Application Number ~~2020/62/91049/W~~ **STRONG OBJECTION TO - 2023/62/91327/W**

PROPOSED SITE PLAN

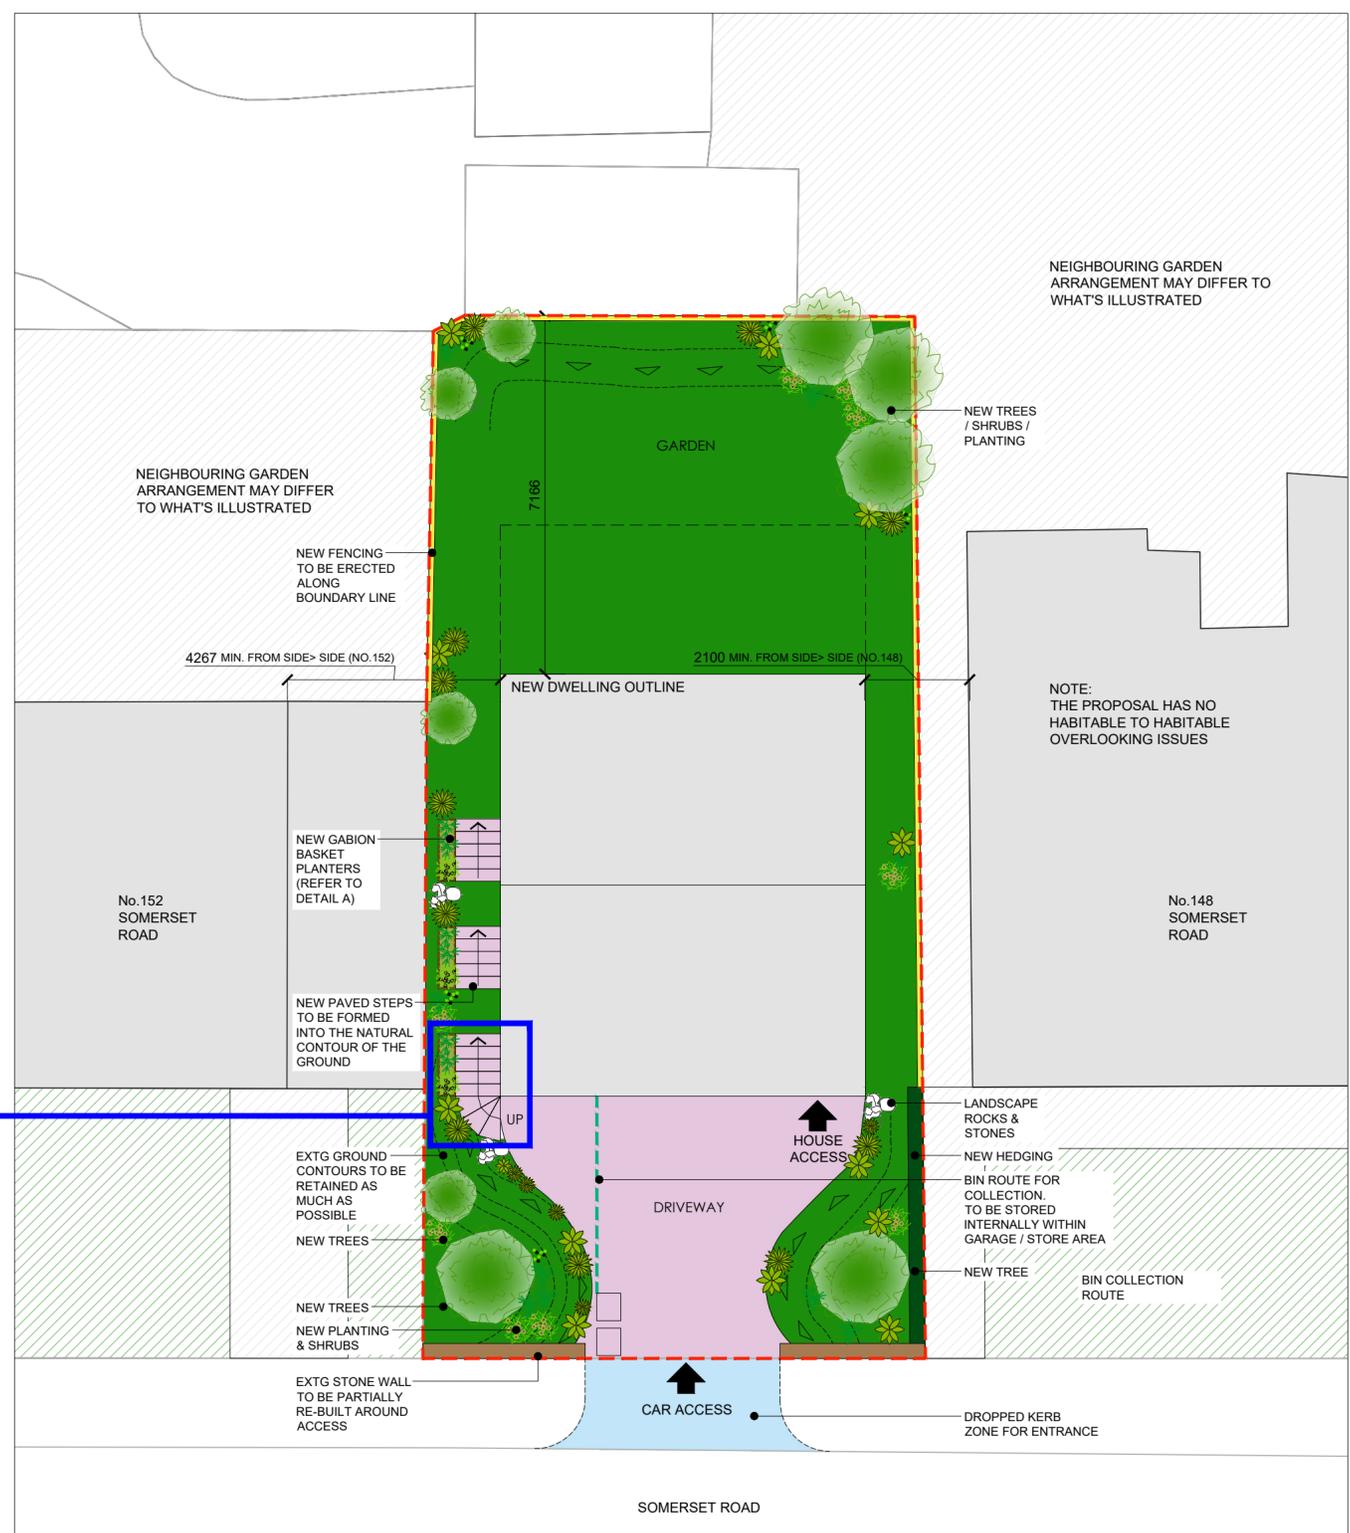
The plan drawings at the rear show the garden for the new property all the way up to the garages and is misleading as access is required at the rear to nr 148 so this would reduce the size of the garden and mean that unrestricted access is required

Looking at the plan drawings there isn't enough room to spin the car around so would there not be a safety issue with vehicles either reversing in to or out of the property on to a very busy main road especially with the amount of cars parked above and below the opening that there would be a massive lack of visibility.

This would also impact on the pavement as cars entering or reversing from the property would have limited visibility on to the pavement as the drawings suggest trees and shrubs either side of the car access area on to a public highway

The frontage of the house is 7.3m wide and the property is 10.0m wide and the parking width/ dropped kerb is 3.9m at the gate side but with the curve of the pavement (as drawn) the restricted access would be approx. 5.9m and the average length of a standard car is 3.4m long, so giving permission to drop the kerb by this length means that 2 cars will be unable to park on the road as access will be required to this property for 5.9m

DRAWING: PROPOSED ELEVATIONS

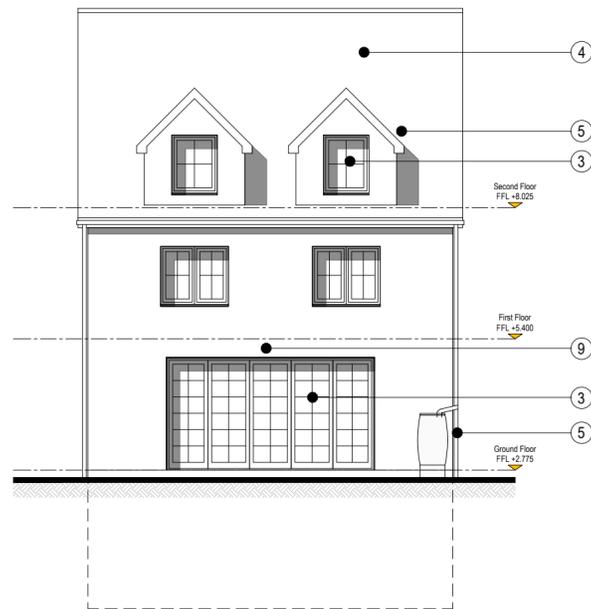
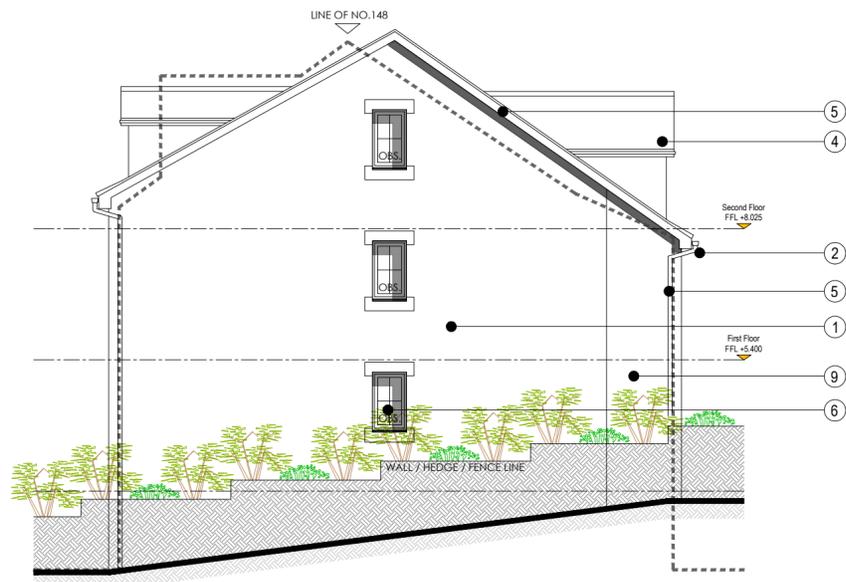
Side elevation drawings show opening windows on both sides of the property and I believe these will be overlooking houses on both sides but on the elevation facing nr 152 these are all bathrooms and there may be a privacy issue here  
*No development should intrude over a line drawn at an angle of 45° in the horizontal plane from the midpoint of the nearest window of a habitable room (includes kitchens but not for example bathrooms)*

I believe this is also contravenes the 'right to light laws' as this will be blocking the sun from several properties  
 4.16 *Any house extensions or alterations are expected to not materially affect the amount of natural light presently enjoyed by a neighbouring property. Therefore, extensions and new builds will not be permitted if they unreasonably overshadow neighbouring habitable rooms and private gardens.*

With the sun rising from the East the loss of light by blocking this would be immense, nr 148 would loose all sun to side window and back garden from sunrise till after lunch about 50% of the sun now and nr 152 would loose all sun to side window and front garden pretty much all afternoon about 75% of the sun
